Application for a Non-Material Amendment Following a Grant of Planning Permission

Detached two-storey commercial unit with associated access

CA/22/01962

Re-arrangement of location of internal staircase to first floor and subsequent relocation of external fire escape.

DATE
 10-11-23
 DRAWING No.
 WM/701/250NM

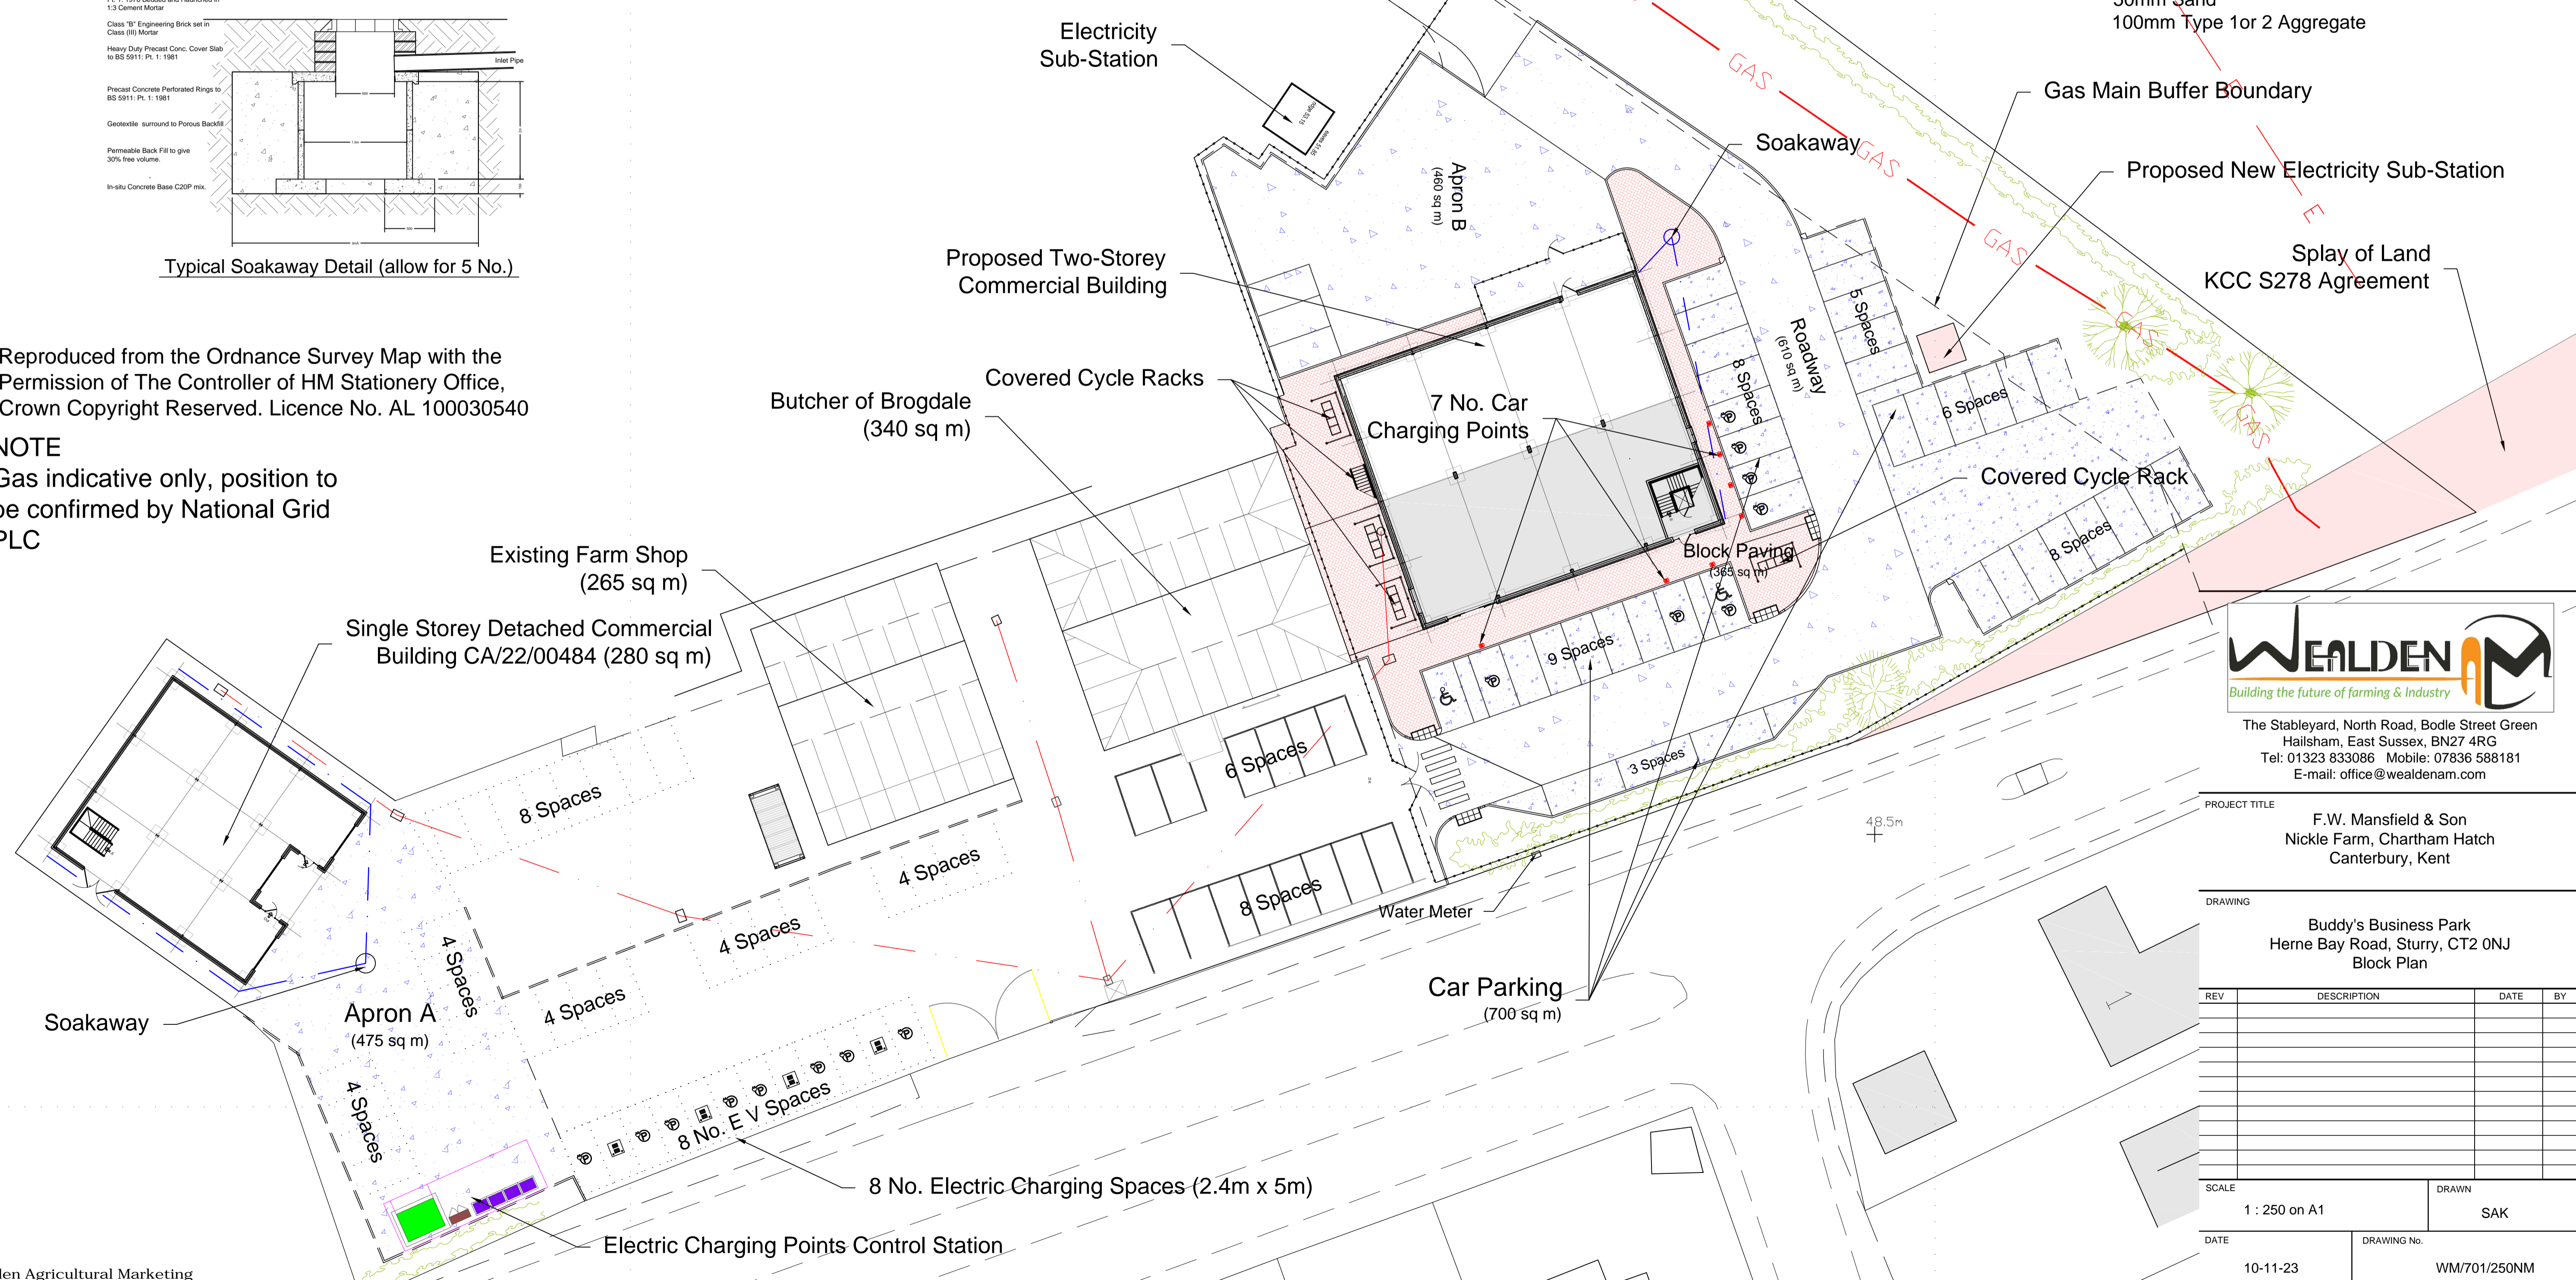
Small increase / re-arrangement of car parking spaces

Minor re-arrangement of cycle spaces

The car parking and cycle spaces have been re-arranged to take account of concerns expressed by SGN after marking out the exact position of the High pressure Gas Main on site

DATE 10-11-23 DRAWING No. WM/701/NM

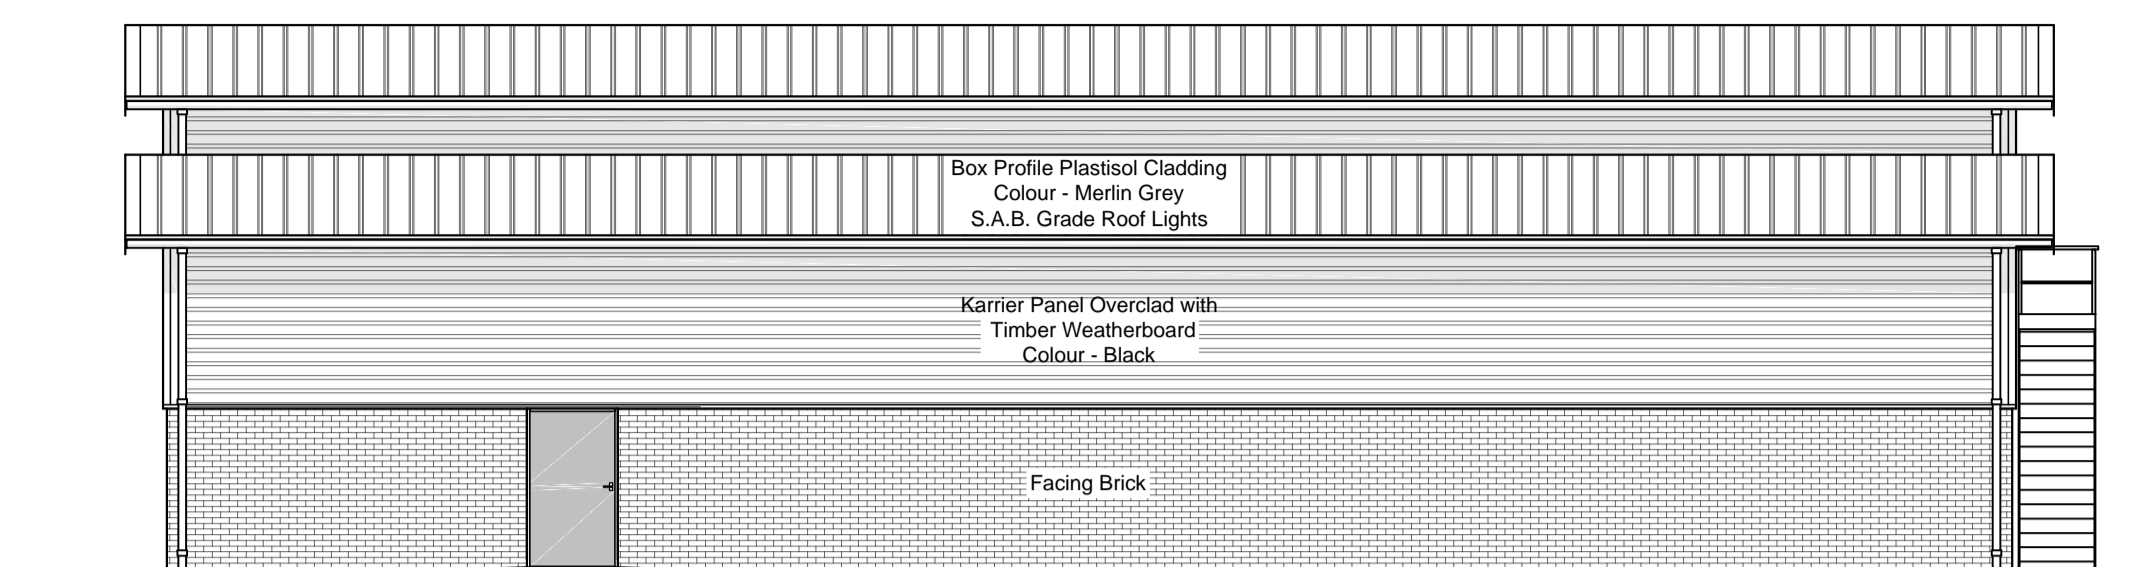
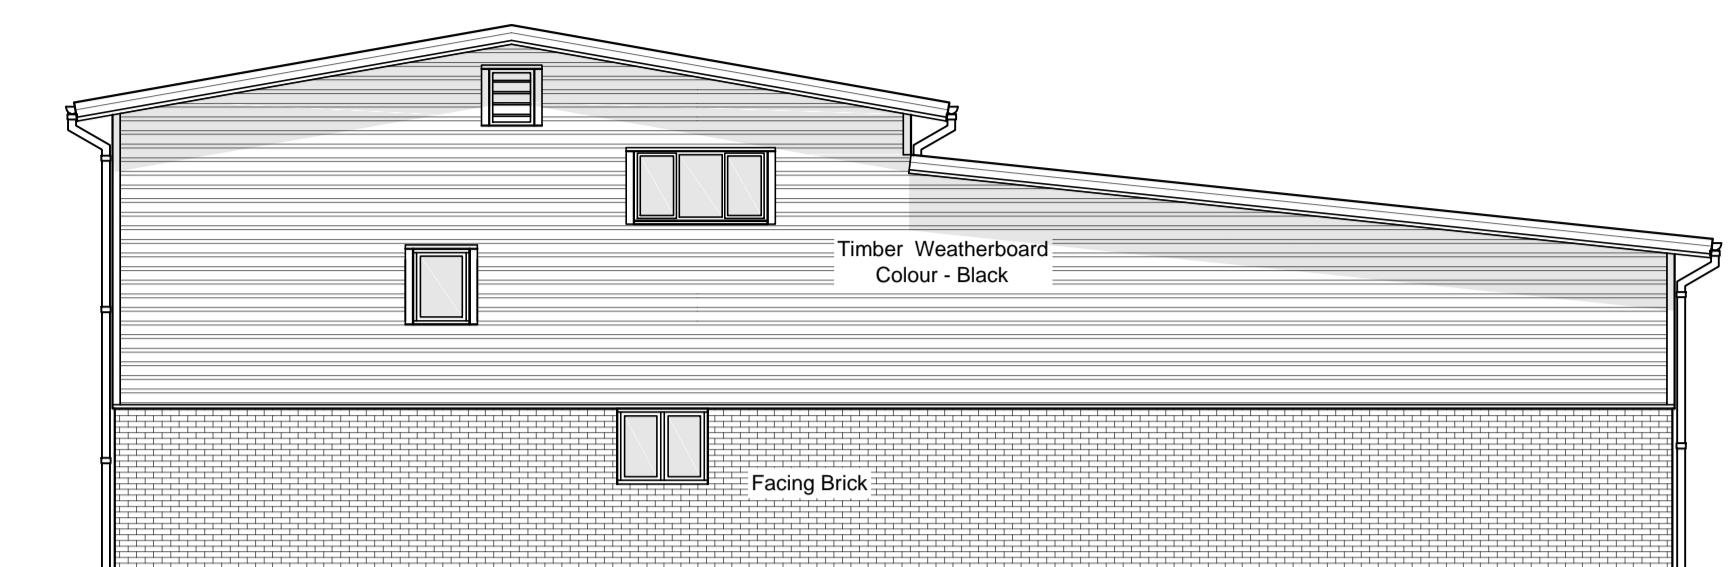
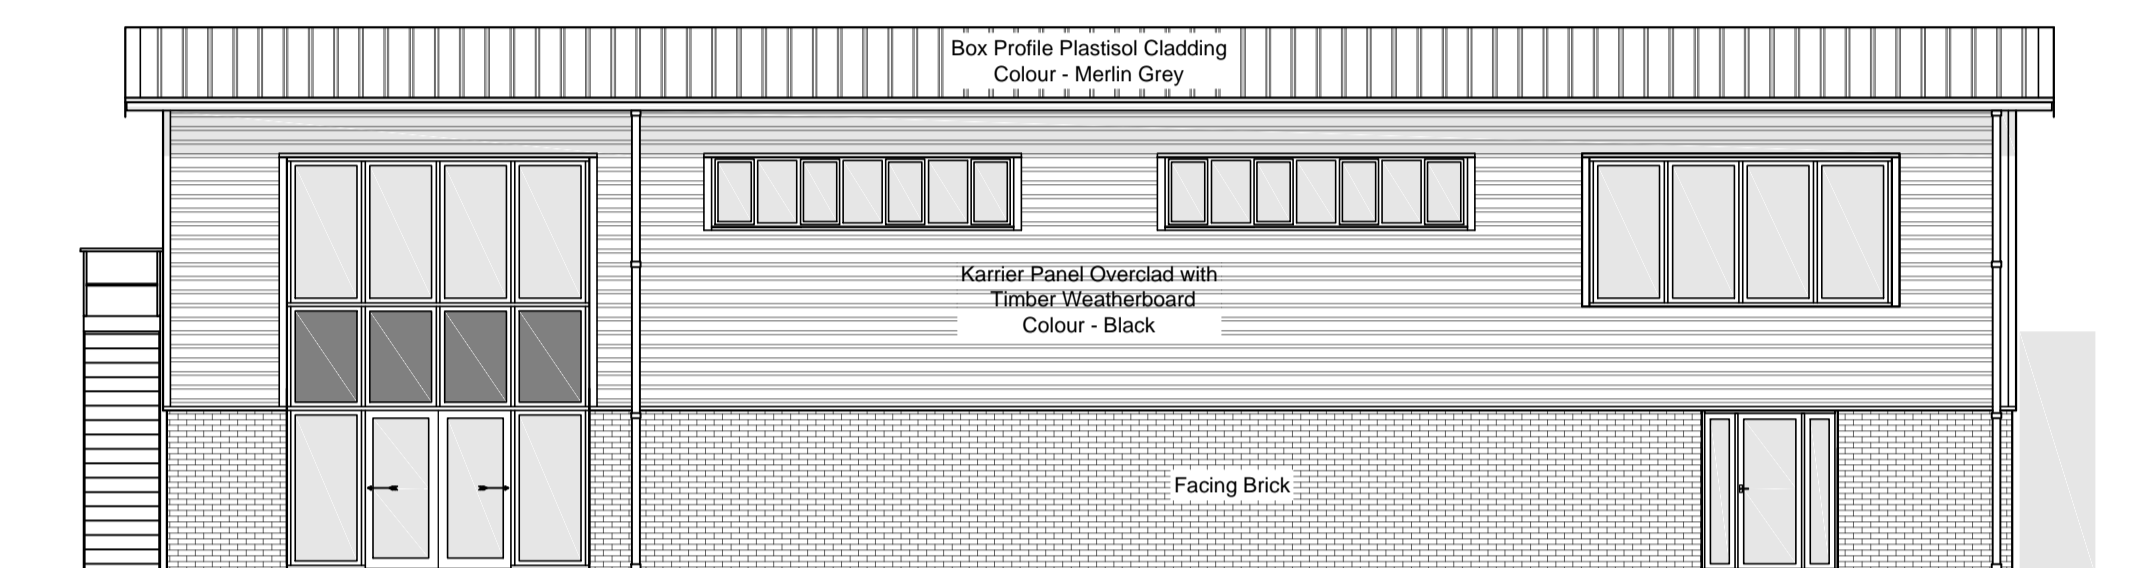
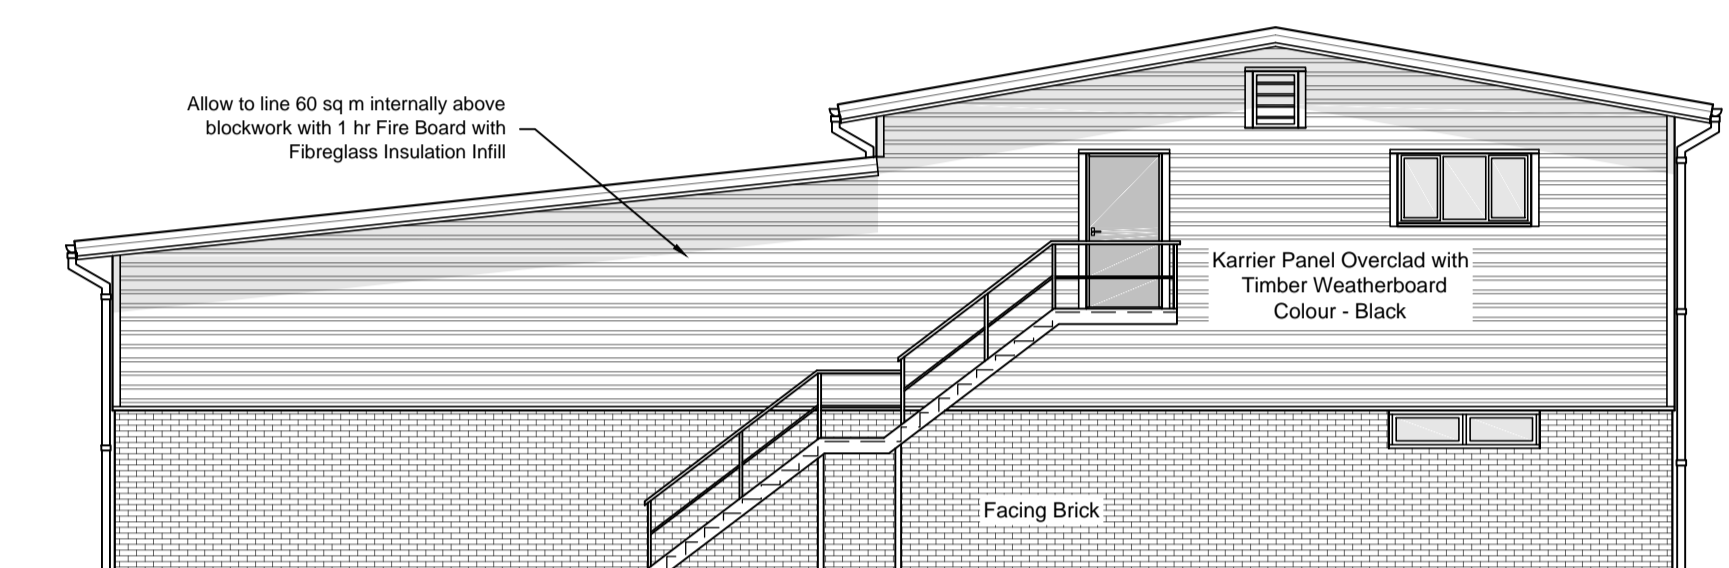
Removal of two smaller windows at ground level

The two smaller windows on the East Elevation have been removed to increase wall space in the retail area
